Anderson Tree Care Ltd

January 29th 2009.

Tree Impact Assessment, **Proposed Extension, Burntwood Hall.**

SITE PLAN SCALE 1:500

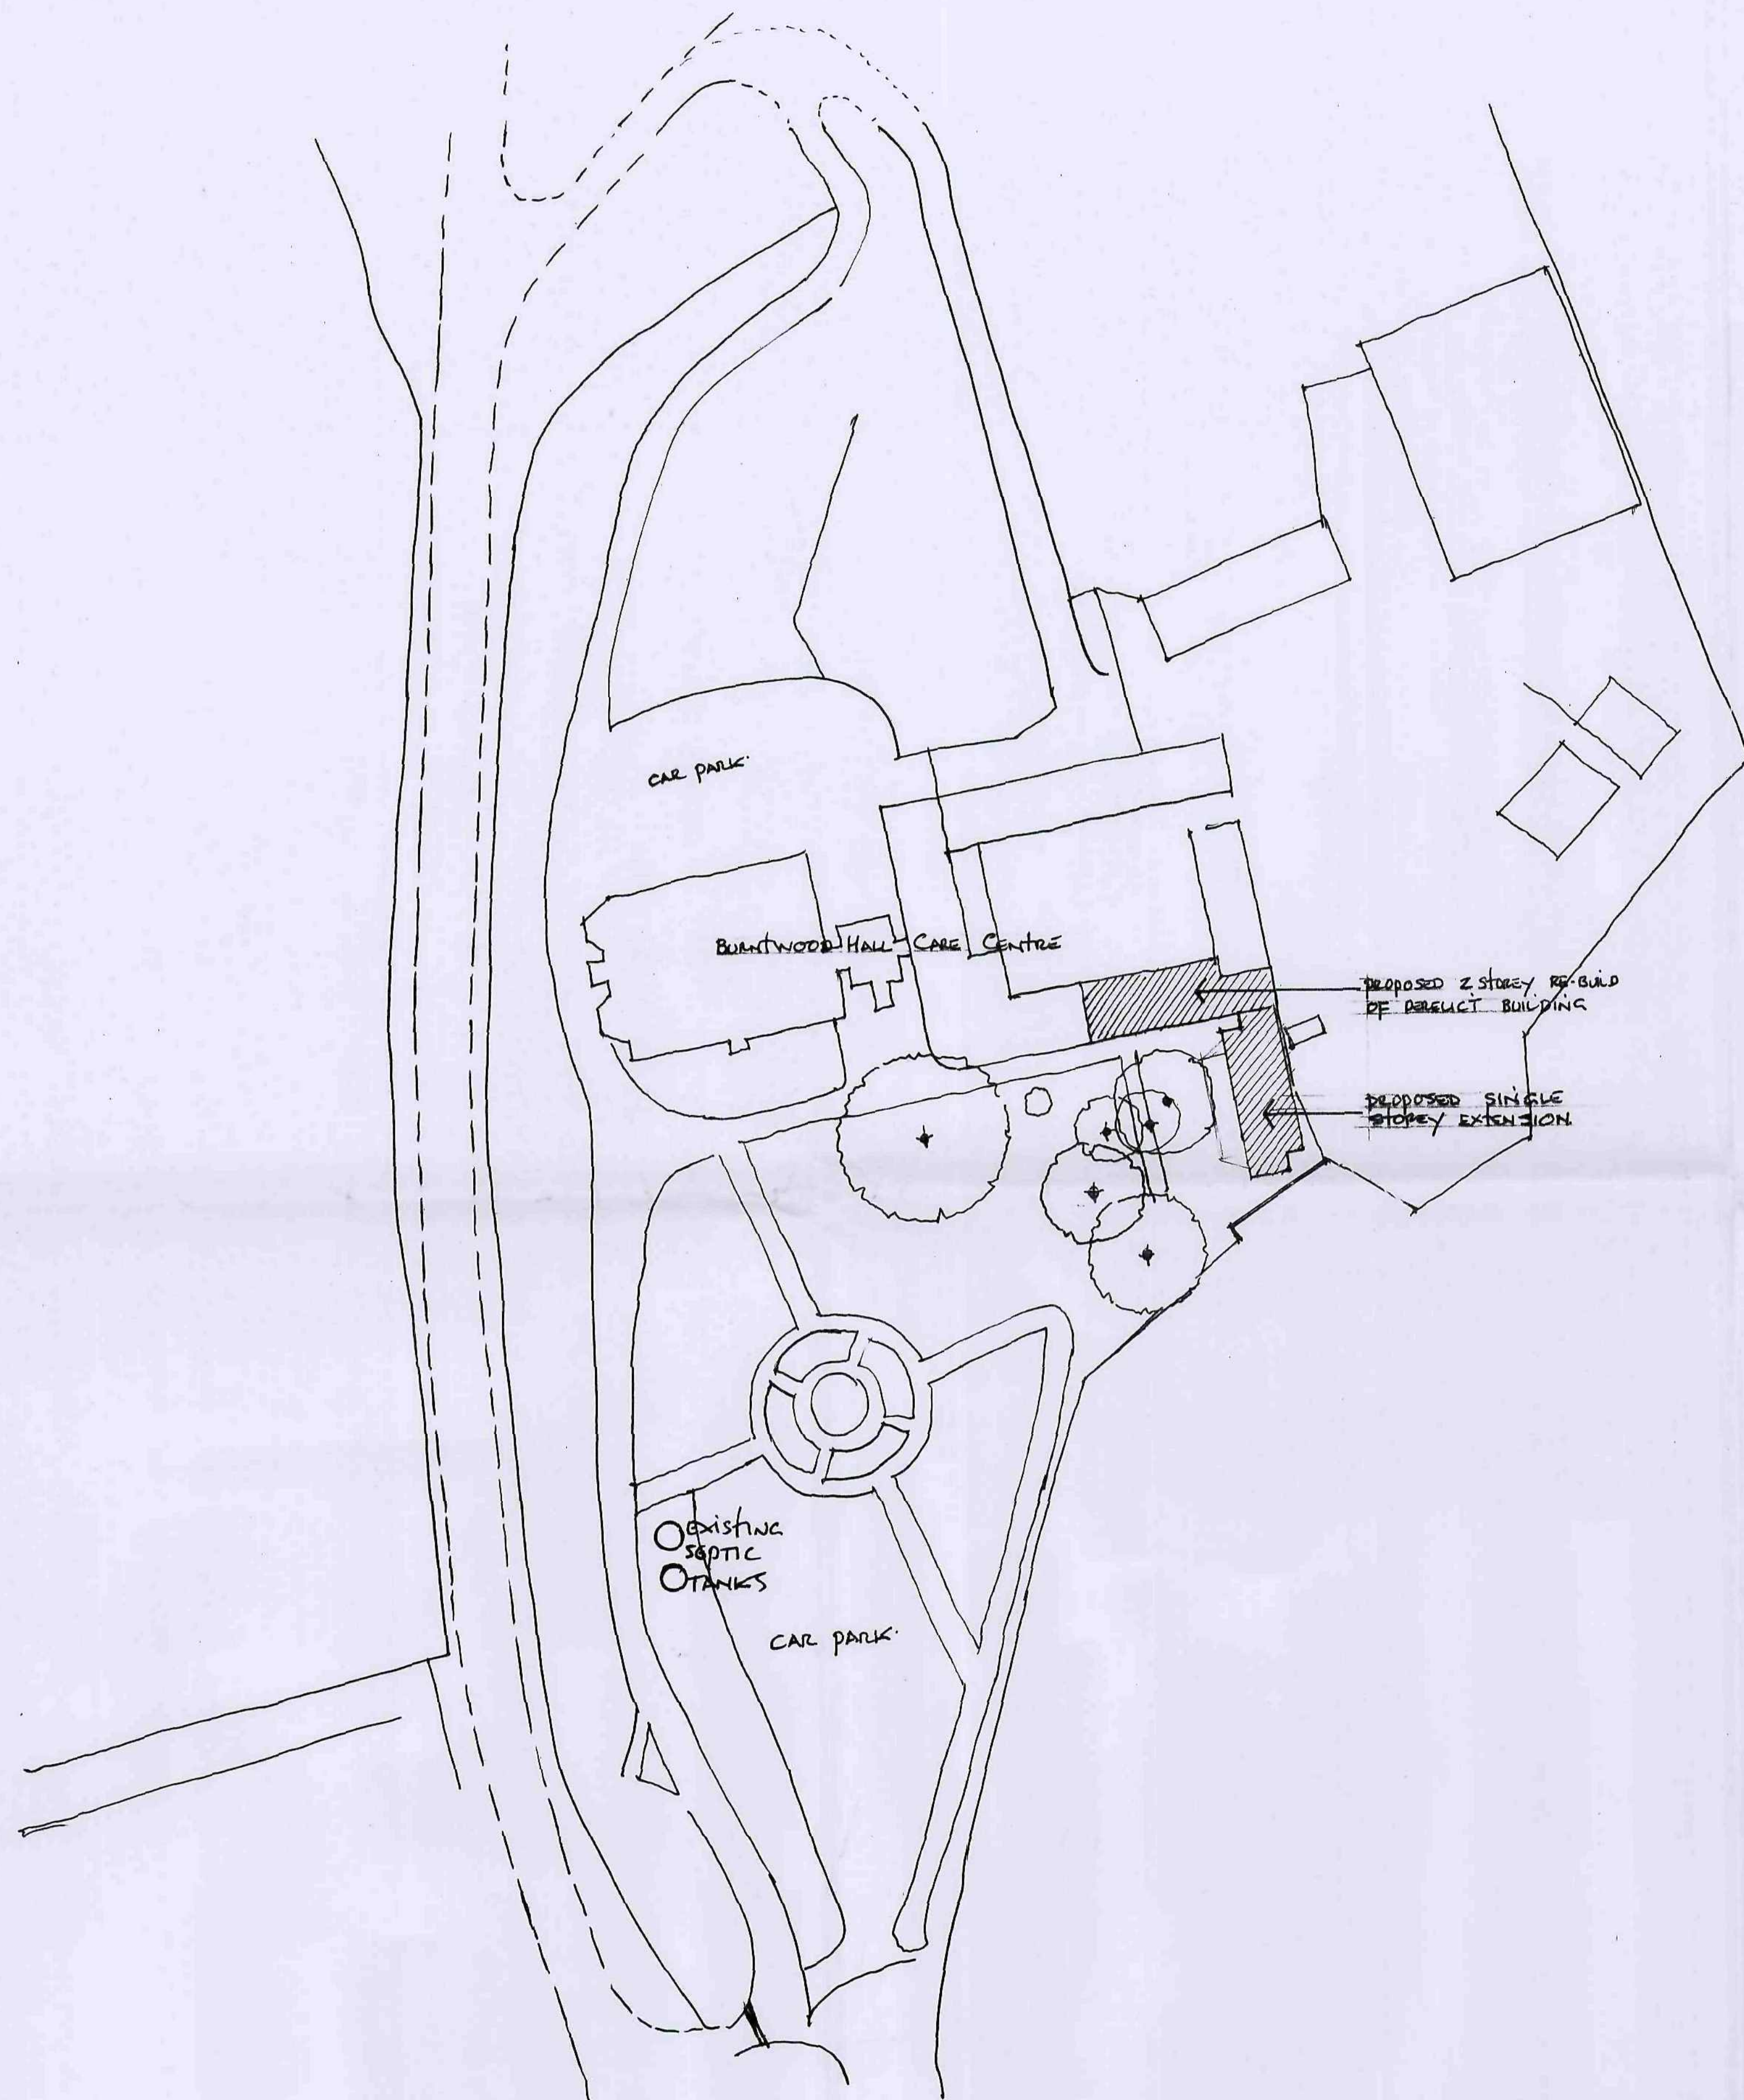
Further to my tree survey you have prepared a plan showing the position of tree protection fencing. Some trees will require removal to permit access to the site and to permit restoration work on the partially demolished part of the Hall.

Trees to be removed are tree 2 False Cypress, tree 3 Pussy Willow, & tree 4, another False Cypress, tree 7 Yew, tree 8 Holly, tree 9 Beech, tree 10 another False Cypress, tree 12 the Laurel, tree 14 the Walnut coppice growth and tree 15 the overgrown Holly hedge.

It is your intention to remove the derelict outbuilding adjacent to tree 5. This will require some work within the Root Protection Area which is acceptable but it should be done by hand and the foundations left in situ unless they can also be removed by hand.

Once the trees designated for removal have been removed the retained trees should be inspected and remedial pruning undertaken if necessary. This is only likely to be necessary for trees 5, 11 and 13, which are rather close to the Laurel 12.
